Memorandum

To:	Norine Allerdice	Date:	June 16, 2022
From:	April Ng		
Project:	Buttenwieser/Wiley Residence 6838 96 th Ave SE Mercer Island, WA 98040 King County APN 302405-9010	File No:	2205-199-INTAKE1
Subject:	Building Permit Intake Response

This memorandum responds to intake comments received from the City of Mercer Island's Community Planning & Development Department dated June 1, 2022 for file number 2205-199 Intake Submittal 1 – Buttenwieser/Wiley Residence.

2 HILLCLIMB SOUTH ELEVATION / SECTION
 A111 / A202 1/4" = 1'-0"
 2' 11 1/8" / 11' 6" X 100 = 18%

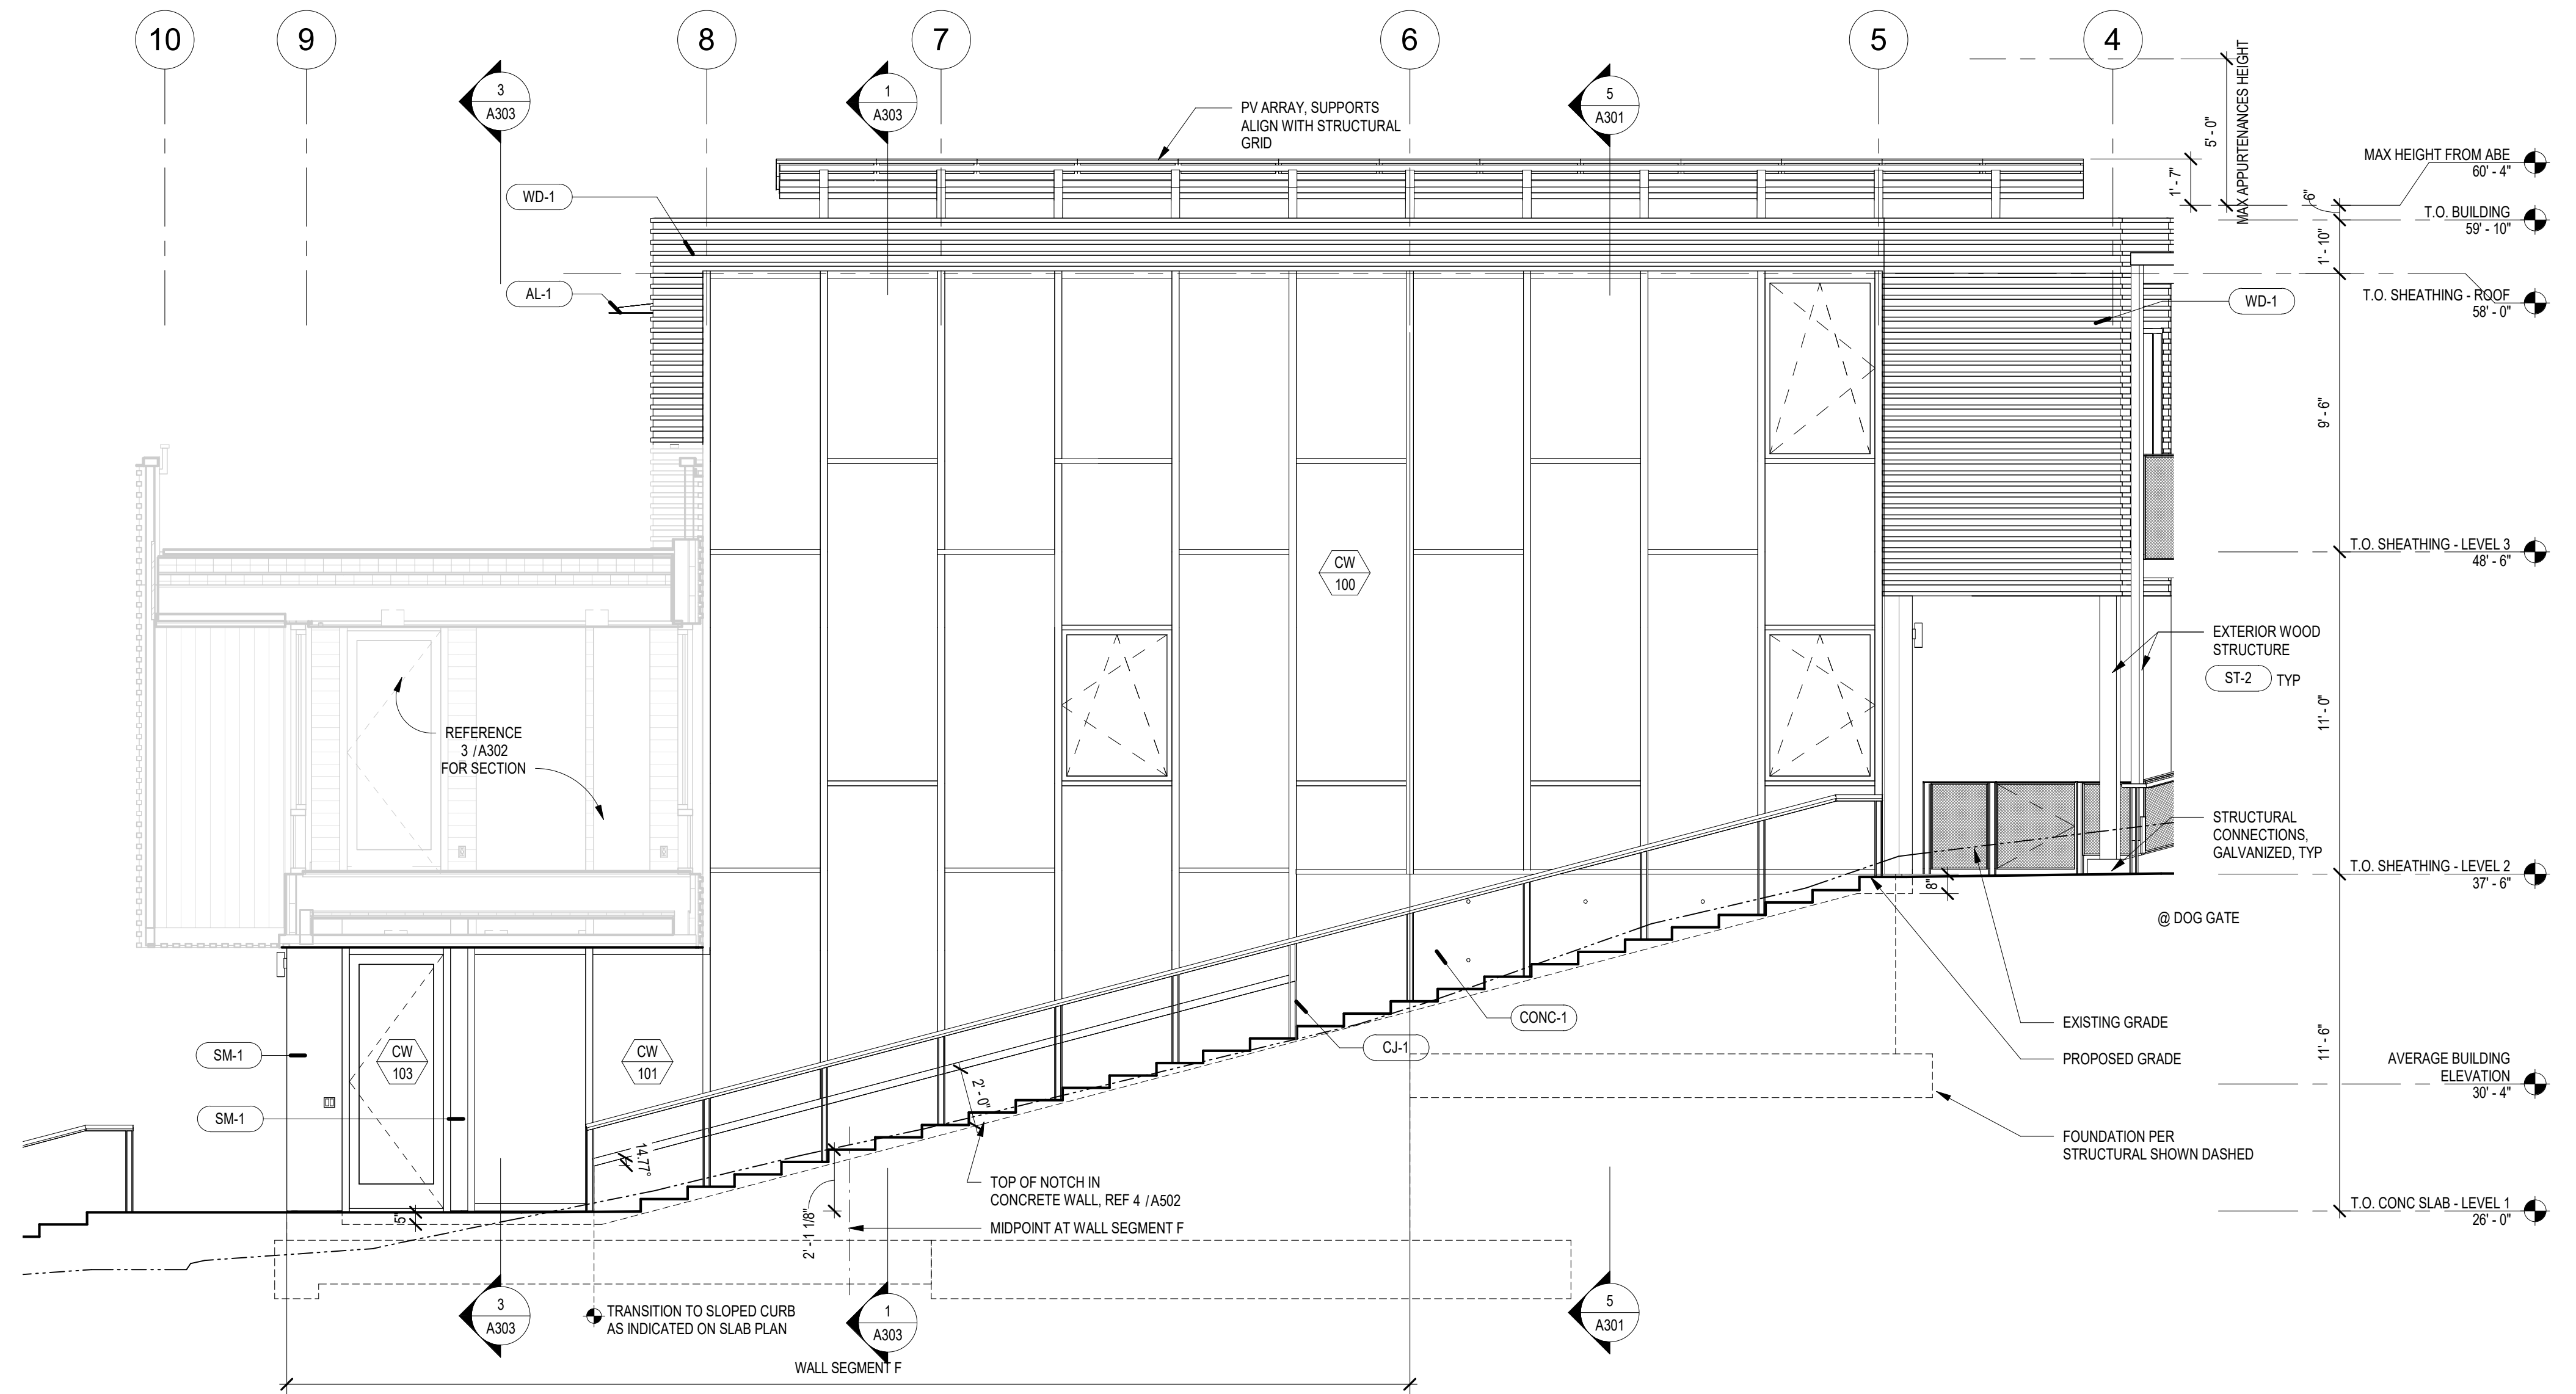
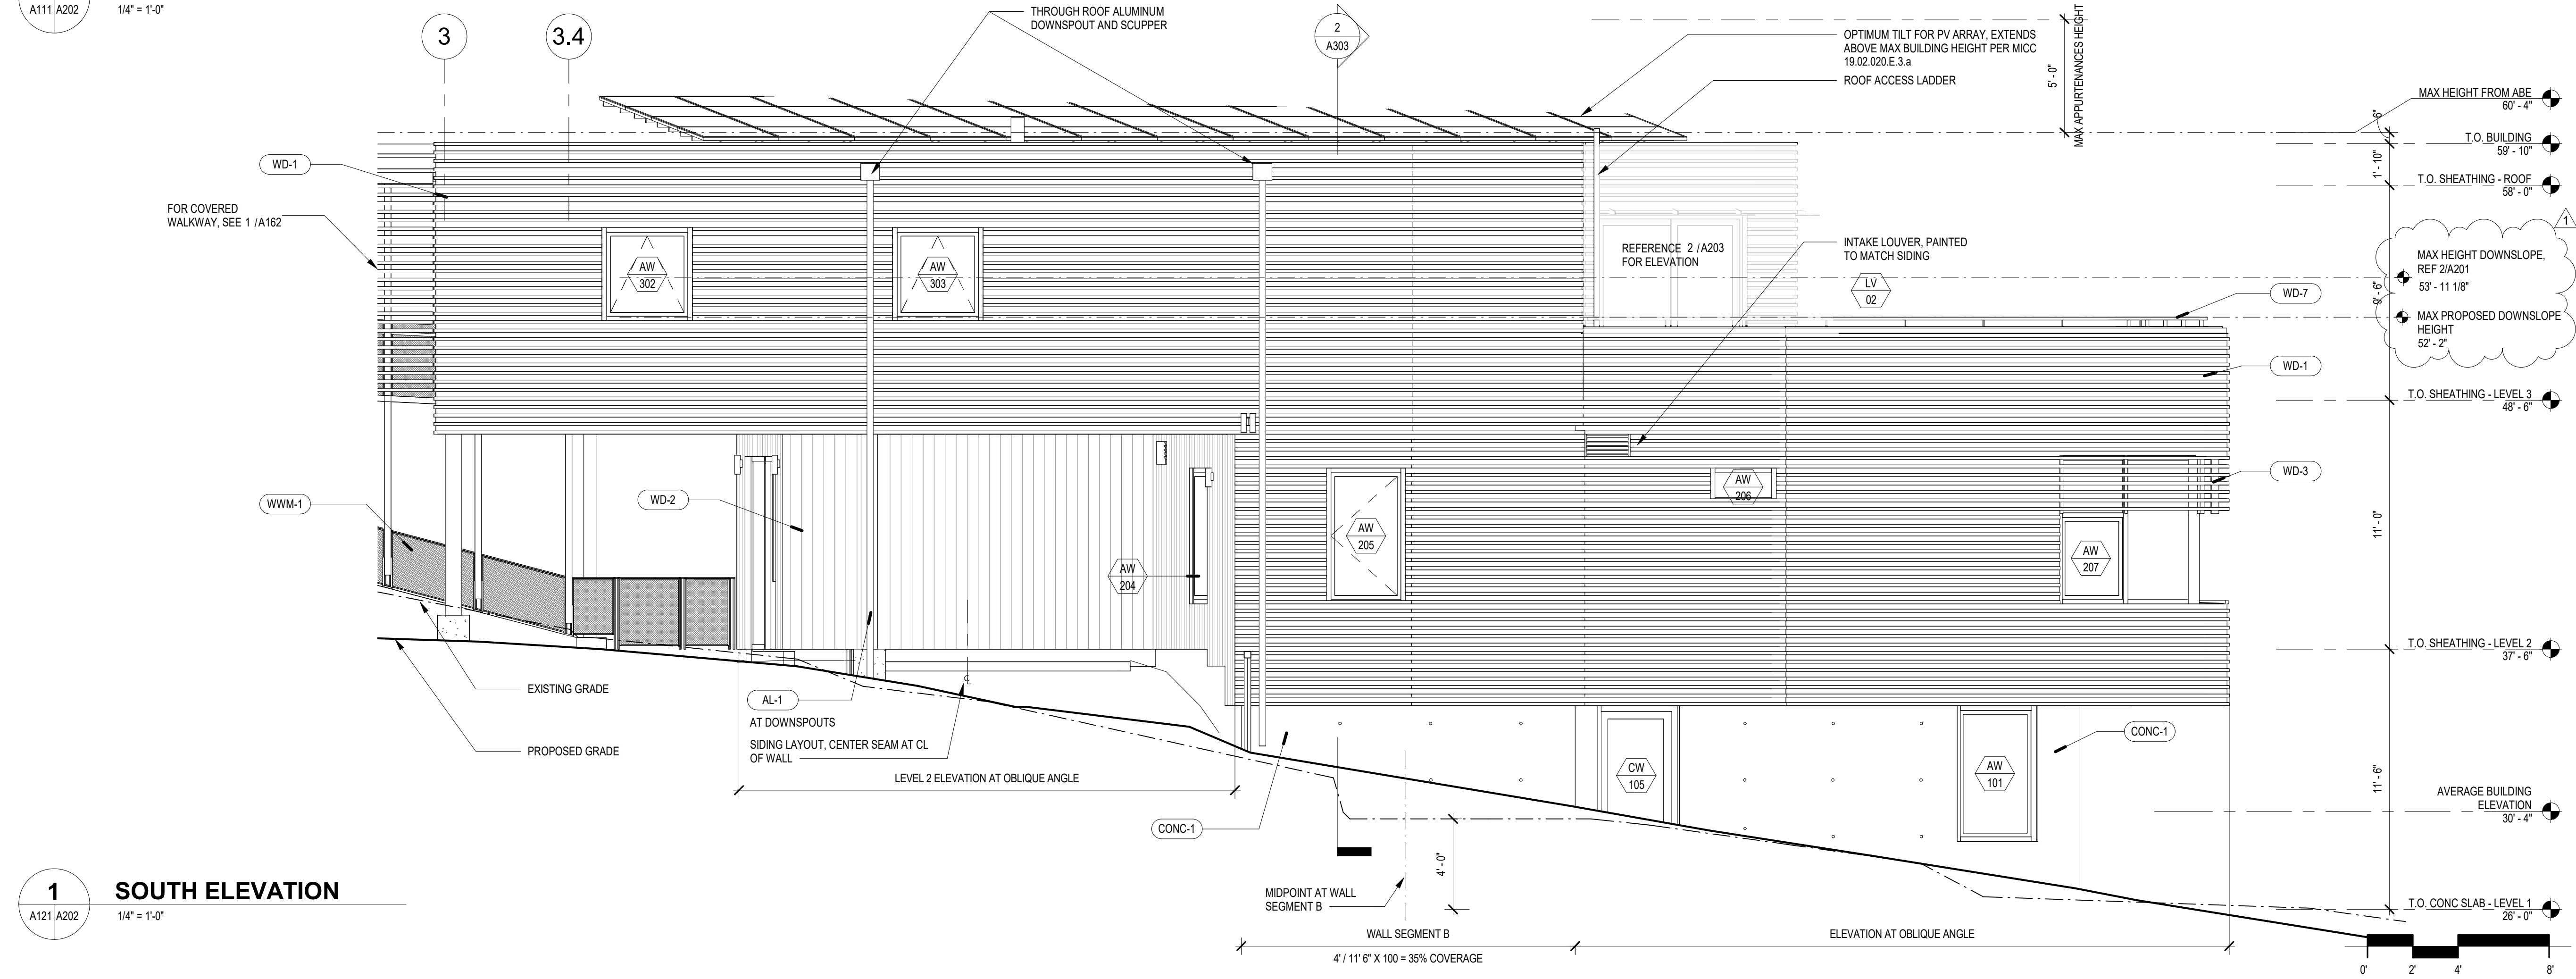
<p>application for an accessory dwelling unit permit. If not, please submit an affidavit stating that the proposed house will not contain an accessory dwelling unit.</p>		
<p>Please show the width and length of the driveway on the site plan.</p> <p>Also, please note that MICC 19.09.040(G) states that no access road or driveway shall have a gradient of greater than 20%. It appears that the driveway for the proposed house may exceed the 20% limit. Please verify that the driveway complies with MICC 19.09.040(G).</p>	<p>Driveway width and length has been included on site plan. Existing driveway is legally nonconforming. Additional documentation has been provided.</p>	<p>2/G101, 6838 96th Ave SE_15_Driveway History</p>
<p>Please show the amount that the PV array on the roof exceeds the building height limit on the elevations.</p>	<p>Max appurtenances height and height of PV array has been indicated on building elevations.</p>	<p>2/A202, 1/A203</p>
